Martin Nugent
01254 828060
D3/12/0788

Drafted 24 October 2012

**Planning Application, Ribble Valley District
3/12/0788 1-3 Greendale View, Grindleton**

Existing Site Plan
And Elevation

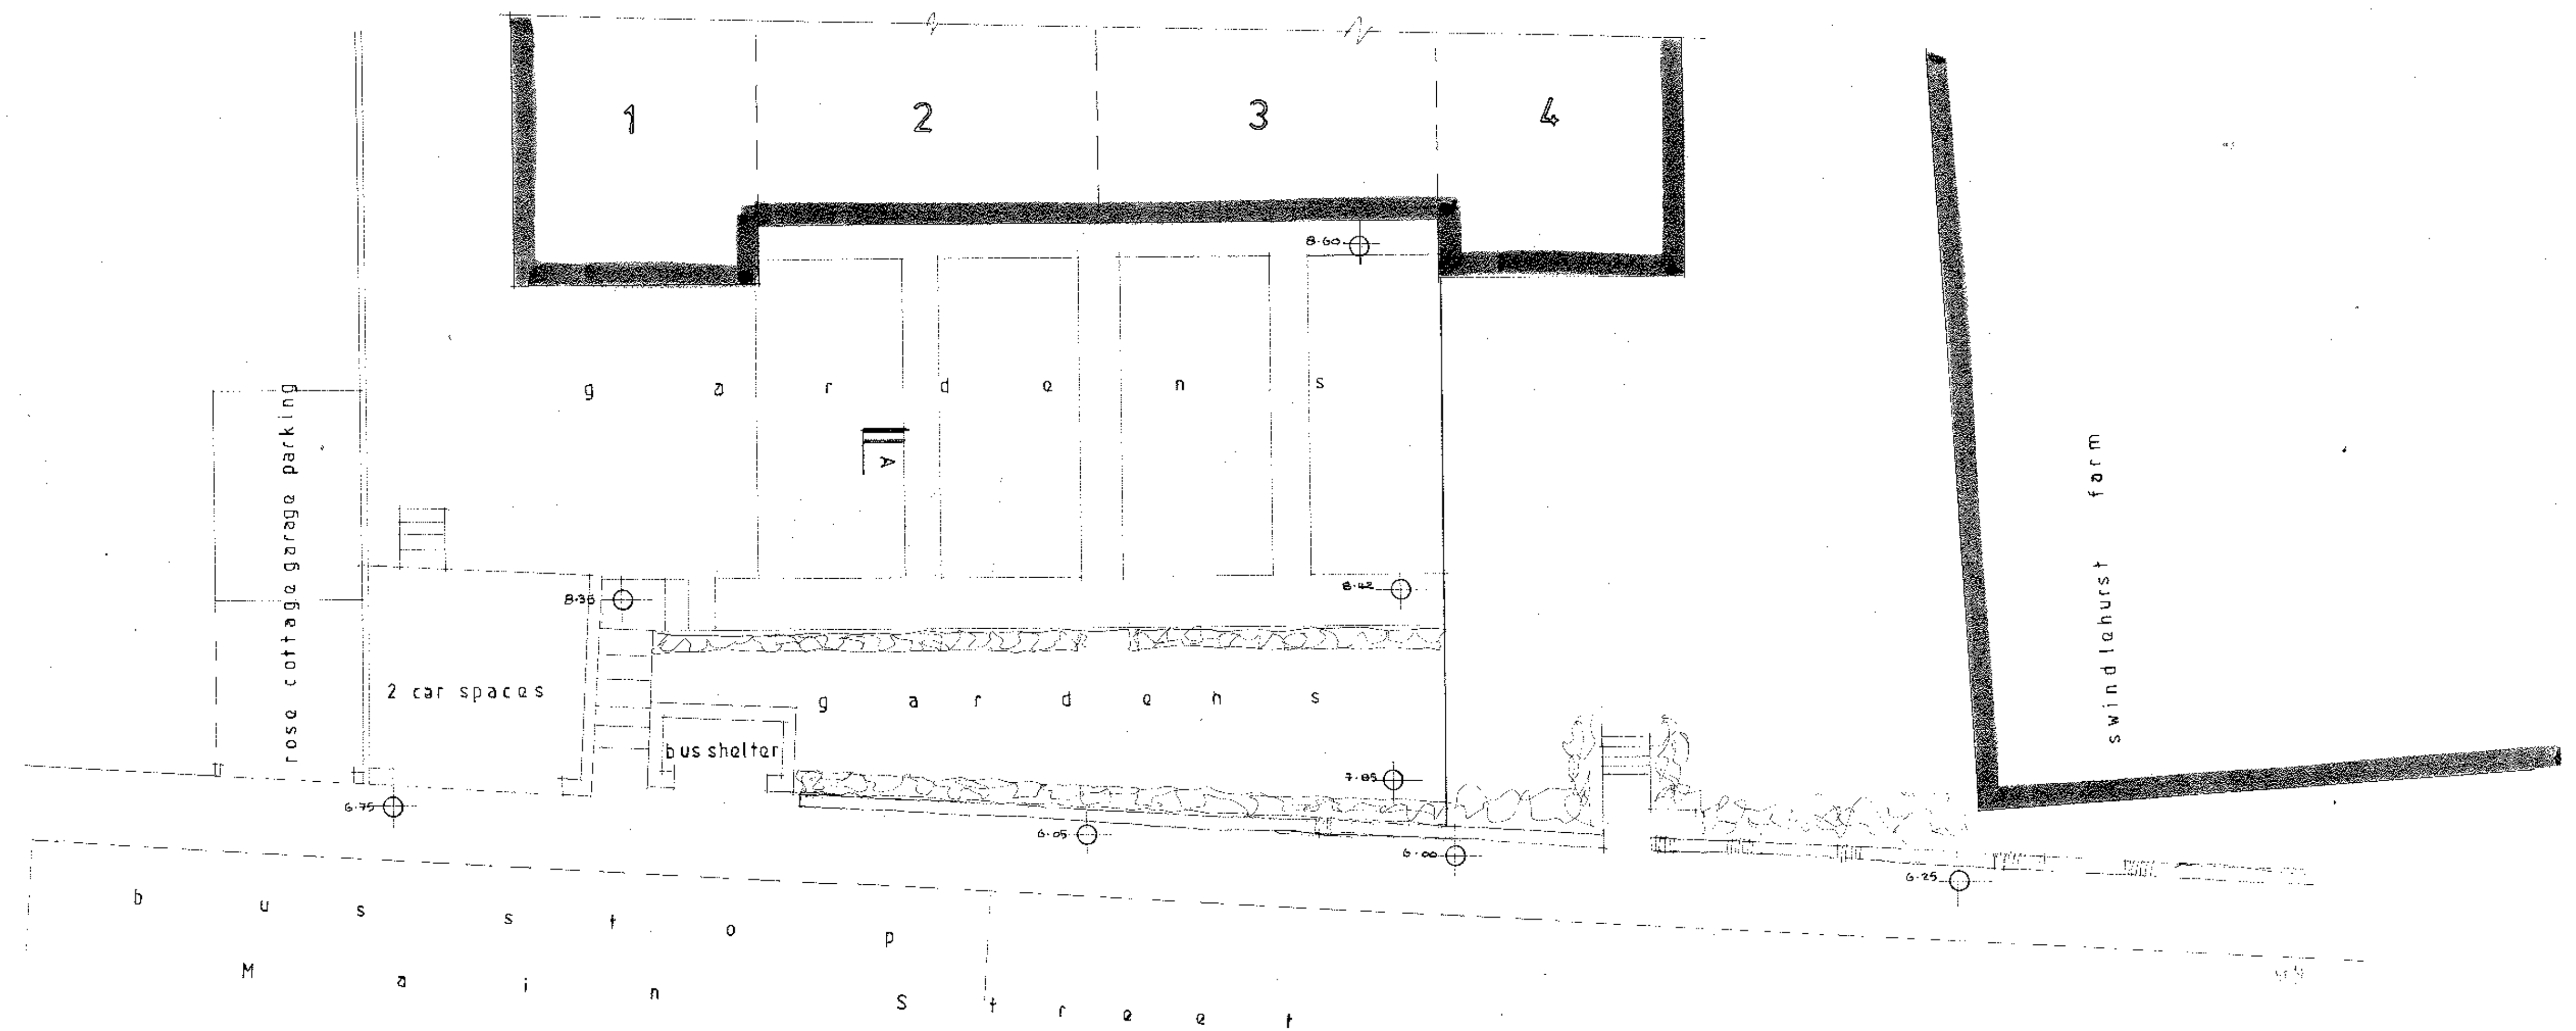
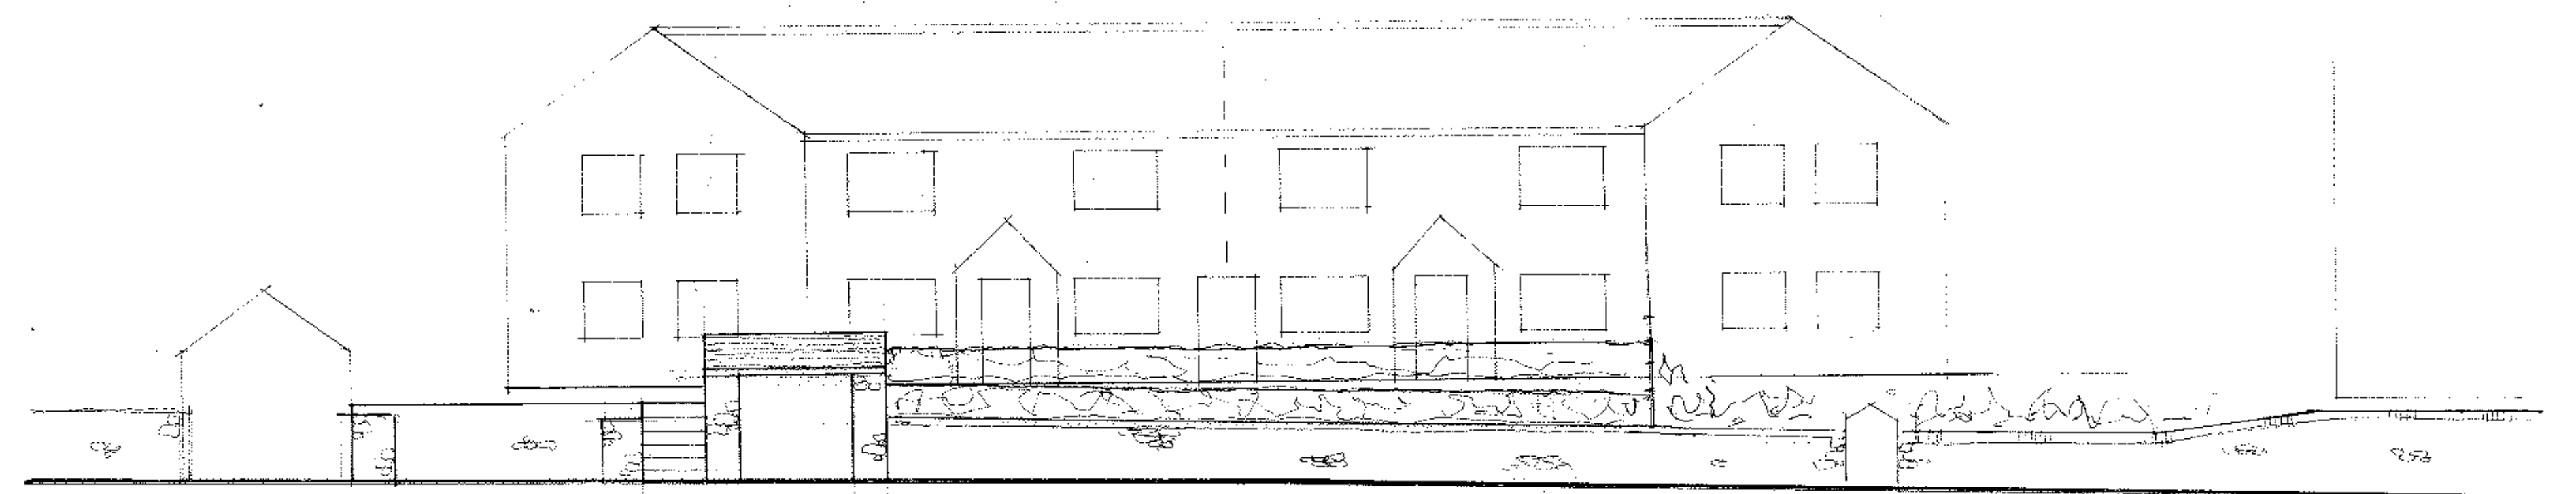
The driveway access is 4.0m in width and has a tight radius. As it is to serve three properties it is reasonable to anticipate that there will be opposed movements at regular times throughout the day. The proposed width will not safely accommodate such movements and could place motorists in a vulnerable position when committing to access the site. It should also be noted that pedestrian access is also required at this point.

There is an existing stepped footpath serving the properties at 1-3 Greendale View and this leads from the north side of the stone shelter. This provision will be lost as part of the proposal and pedestrians will access their properties via the paved driveway, leading to a short series of steps.

I would also point out that drop kerbs should be provided across the proposed new access in order to retain a continuous and accessible footway link.

The public transport amenity enjoyed by residents is retained with the provision of a new shelter, necessary as a consequence of the proposed demolition of the existing stone bus shelter

S.J. Bislecki Limited Building Surveyors
Drawing no. 5007
Scale 1:100
Sections
Proposed Vehicular Access And Car Parking At 1243 Greendale View Main Street Grindleton

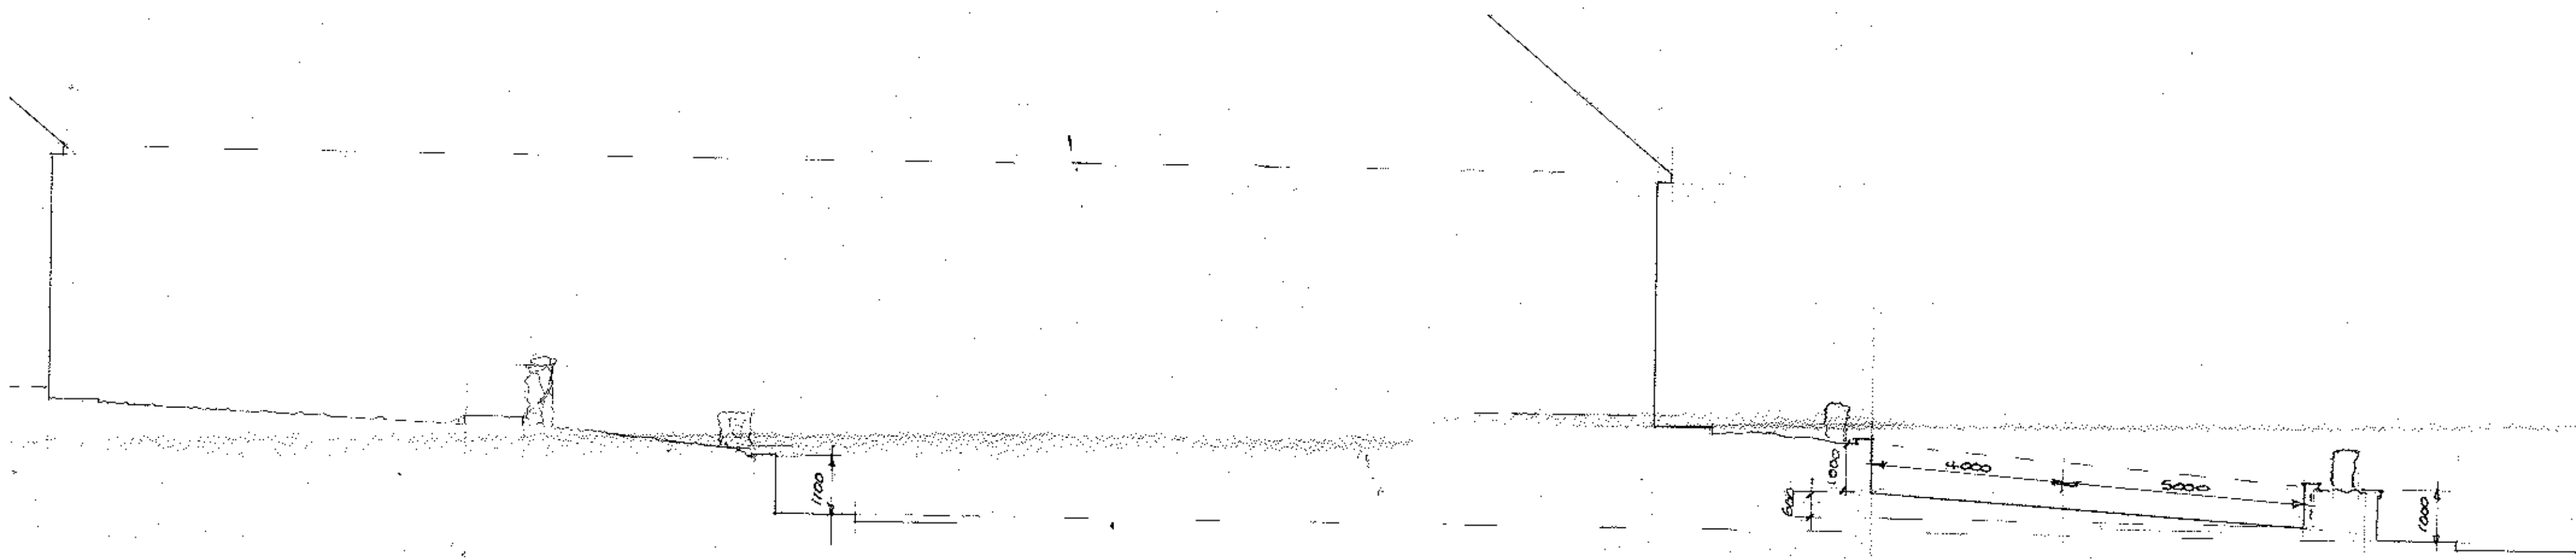
The gradient from the site to the highway is also a concern. I have looked at the available levels and calculated that there is a greater than 1 in 13 drop to the existing footway, a ratio in excess of the acceptable recommended maximum of 1 in 20 from a site to an adjacent highway.

The extreme limit for a footway is 8% and anything beyond this would have to have to be supported with a pedestrian guardrail. The proposed shared driveway approaches this absolute maximum and there is no pedestrian designated route or additional provision such as a handrail.

I would also welcome a detailed drawing of the 1.0m high retaining wall proposed along the front of the three properties and to the back of the driveway. This is to confirm it is of suitable dimension.
